WEST SUSSEX COUNTY COUNCIL CONSULTATION

TO:	Arun District Council FAO: Mr. S. Davis
FROM:	WSCC – Highway Authority
DATE:	21 January 2025
LOCATION:	Land adjacent to Woodgate Nurseries Lidsey Road Aldingbourne PO20 3SU
SUBJECT:	AL/143/24/RES Approval of reserved matters following outline consent AL/129/21/OUT for 95 No residential dwellings with associated parking, landscaping, open space (including play areas), infrastructure and works. This application is in CIL Zone 3 and is CIL Liable as new dwellings.
DATE OF SITE VISIT:	n/a (desktop study undertaken – site visited at outline stage)
RECOMMENDATION:	Modifications Recommended

DS 0707 15/INF/301 B

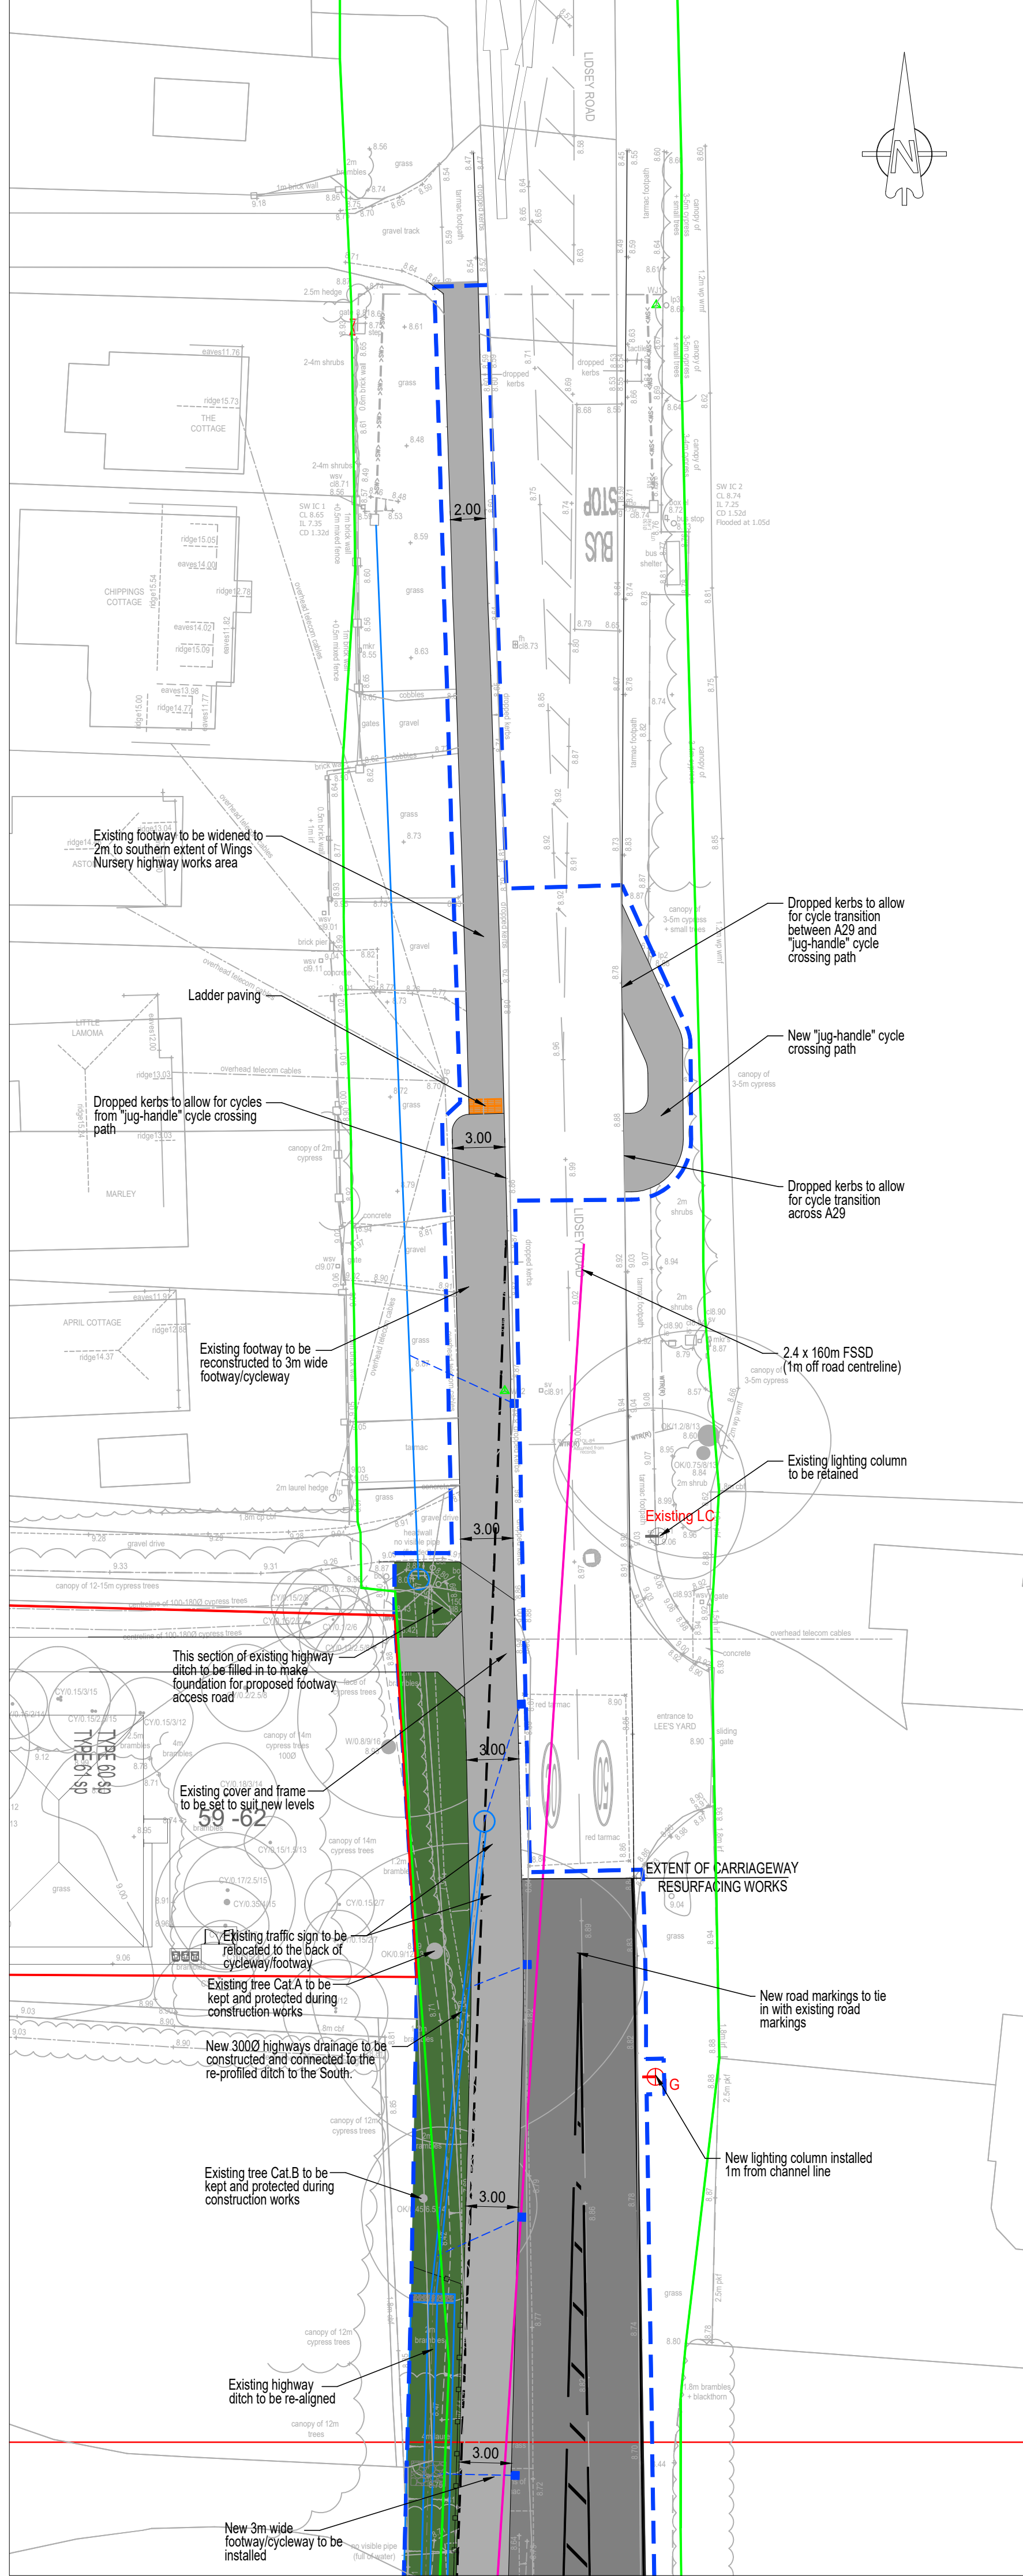
- The Highway Authority recalls that the connection in the NE corner of the site was supposed to be shared foot and cycle (it is currently shown as a footway only). Applicant to amend this. **Applicant response:** A cycle path extends into the main site access, connecting to improved cycle infrastructure that is being progressed along Lidsey Road as part of S278. This provides a combined foot/cycleway from the site access and extending north of the site along Lidsey Road, allowing for improved accessibility to facilities and services (see plan DS_0707_15/INF/301 B). A footpath connection is provided in the site's north-eastern corner.
